From: Martyn White
Sent: 08 July 2019 13:24
To: Planning.Responses <Planning.Responses@arun.gov.uk>
Cc: Amber Willard <Amber.Willard@arun.gov.uk>
Subject: AW/122/19/L

AW/122/19/L

The application is for various works to the property. It has been identified as a listed building

Drawing	Proposed porch

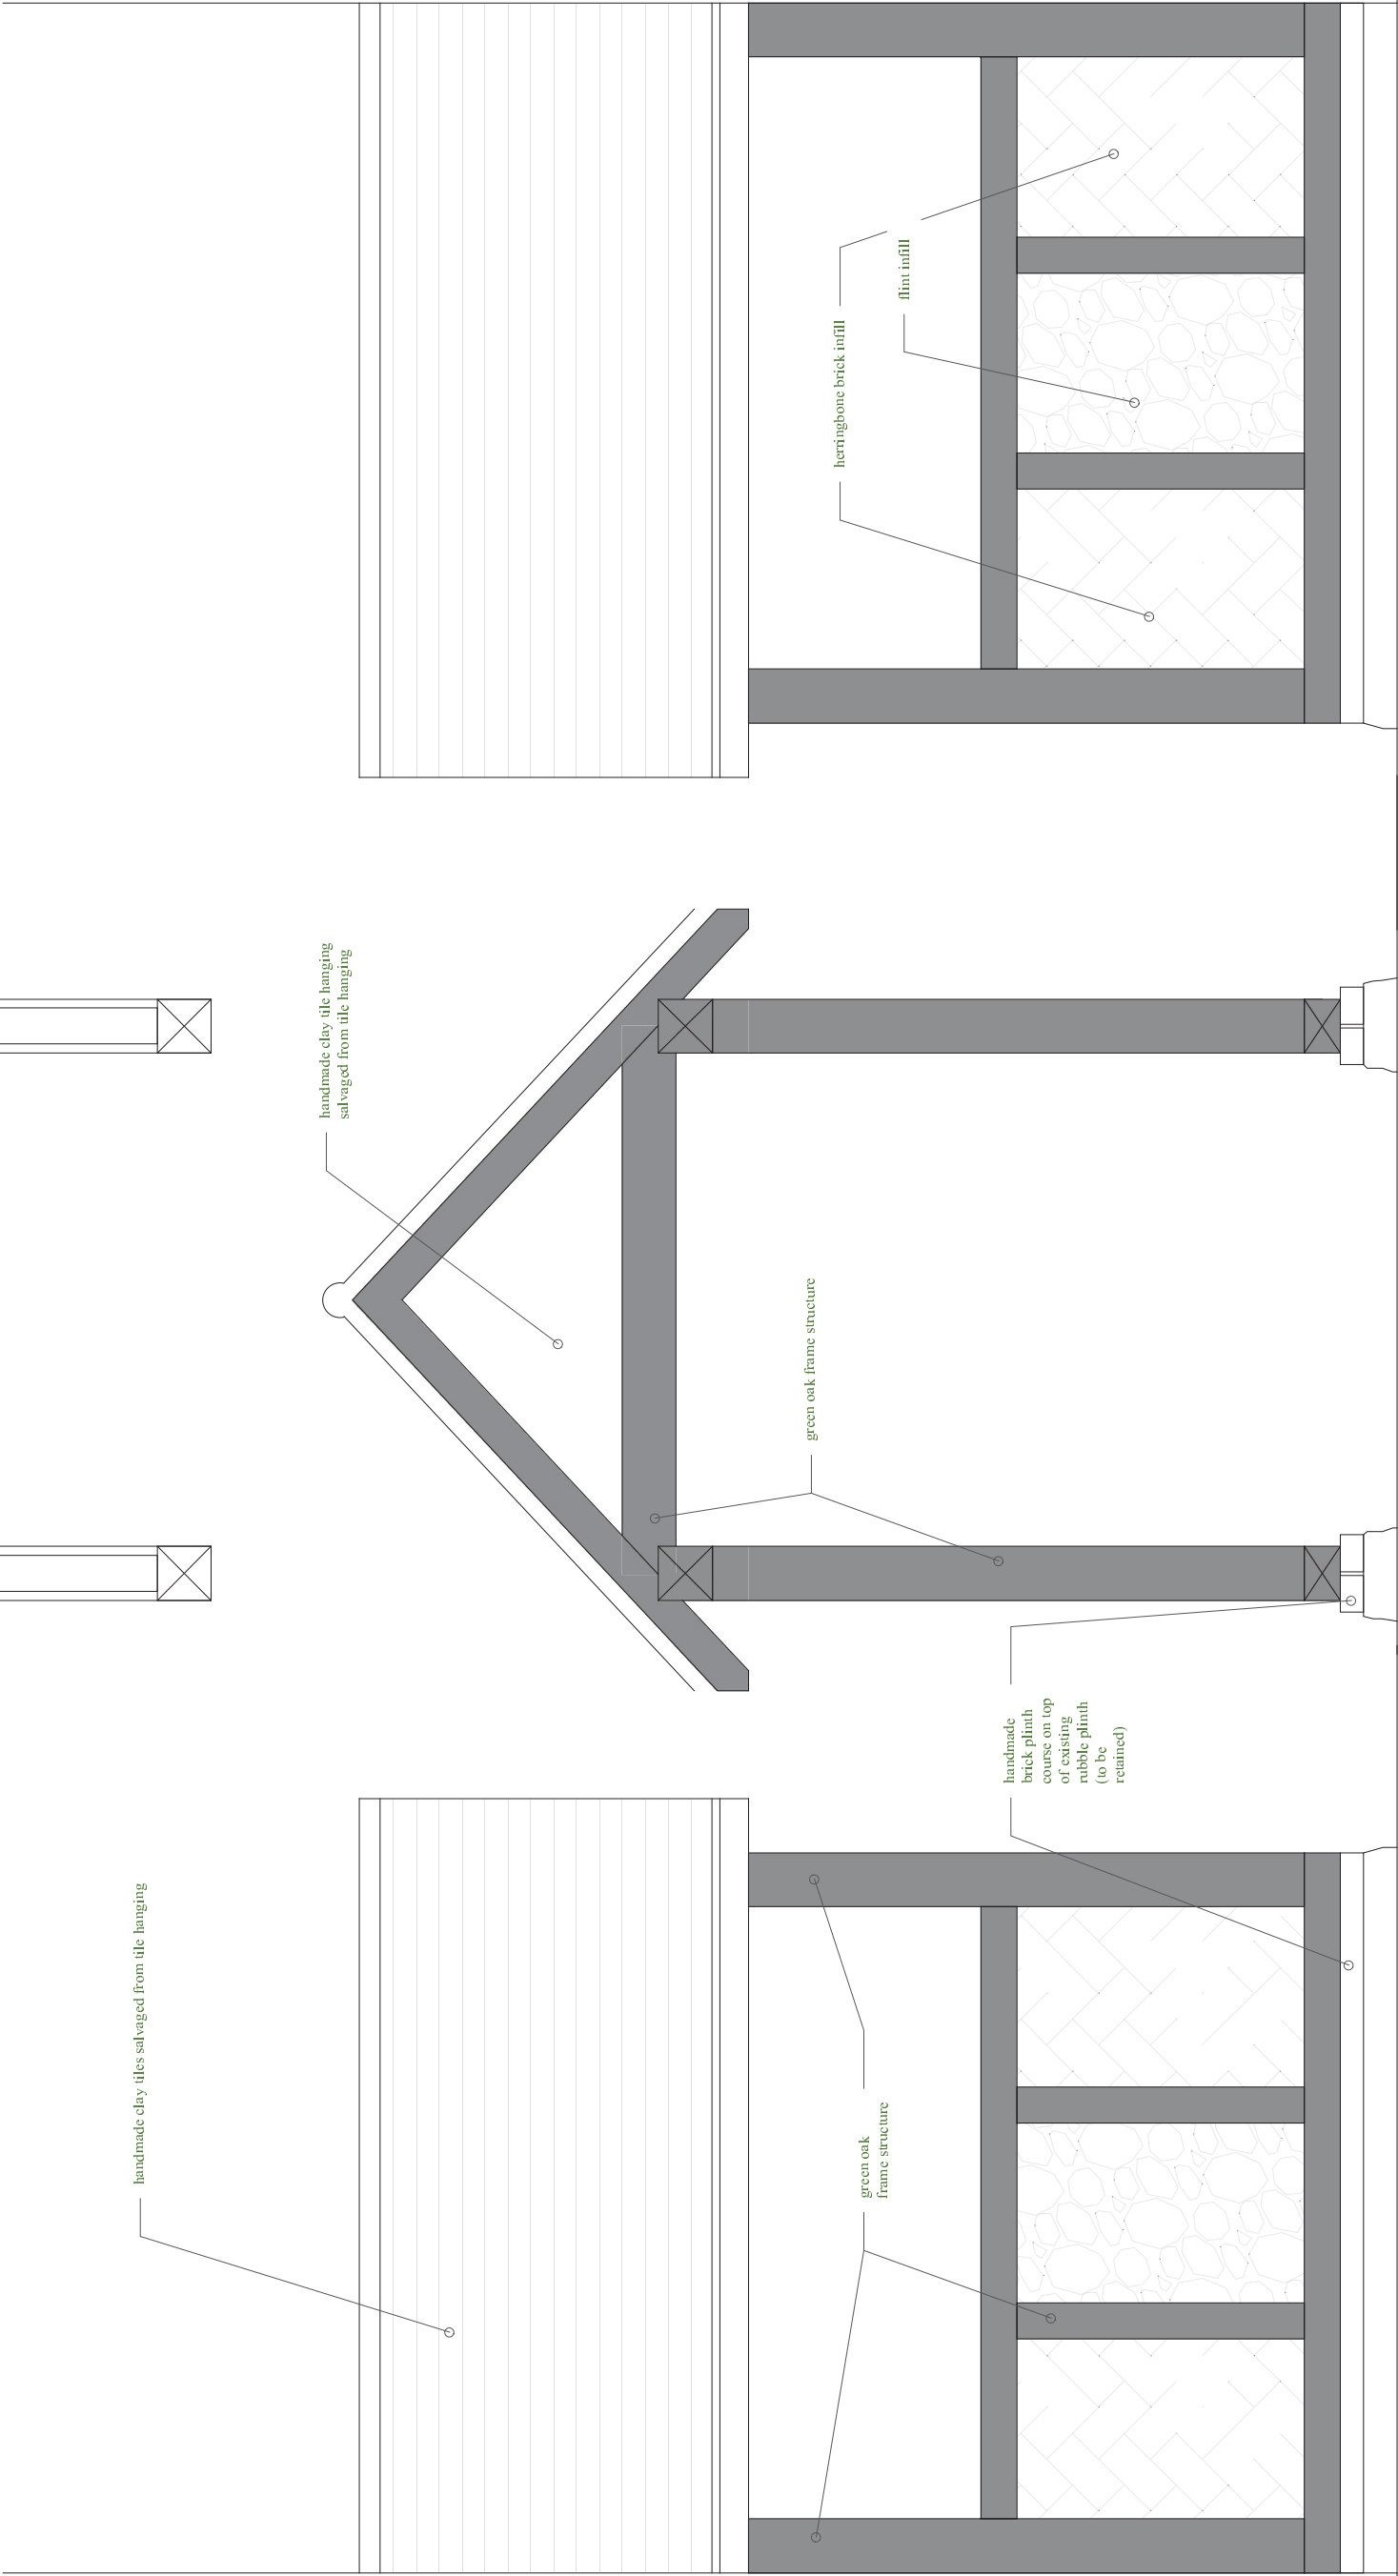
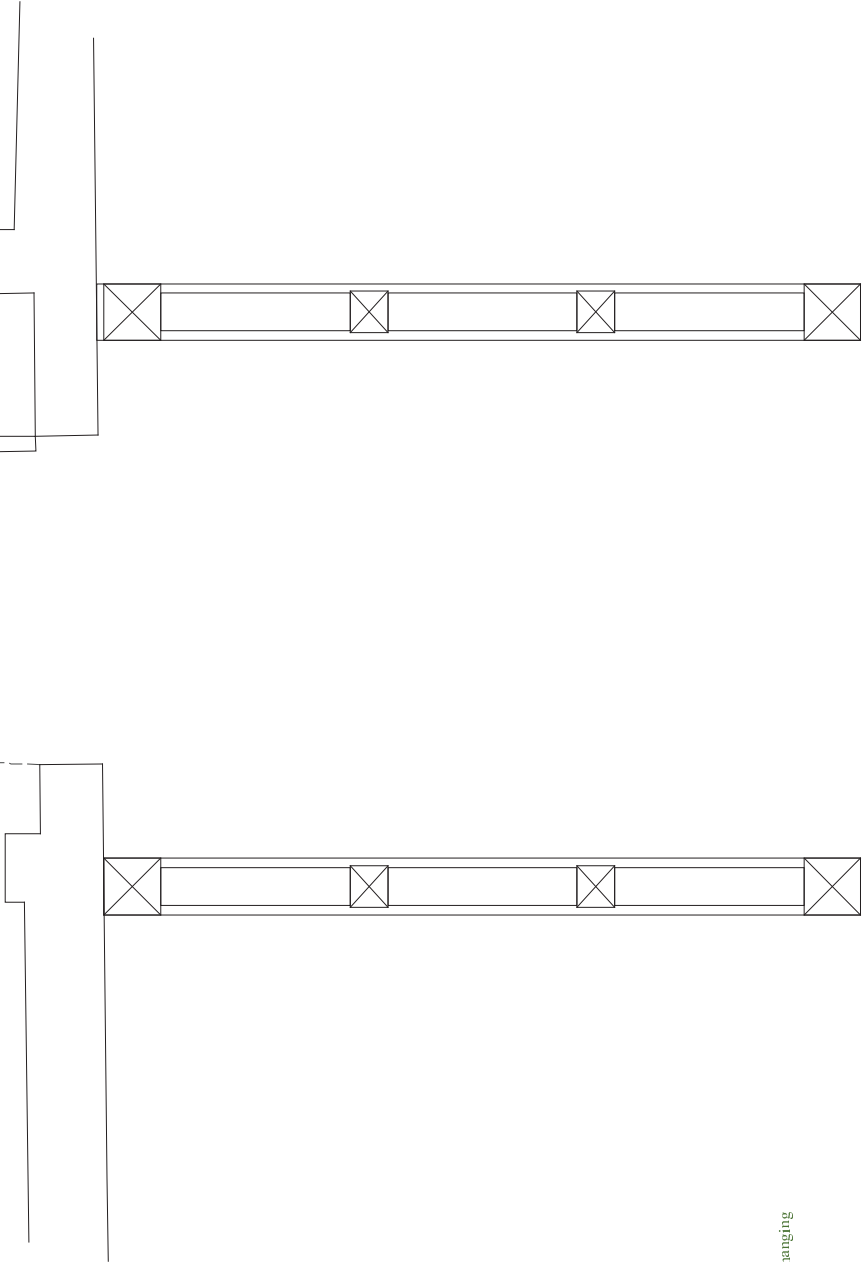
A Sample of the flint panel should be provided for the porch in order to ensure that it reflects the existing porch and other areas of flint within the property. Likewise, the mortar should reflect the existing in terms of appearance.
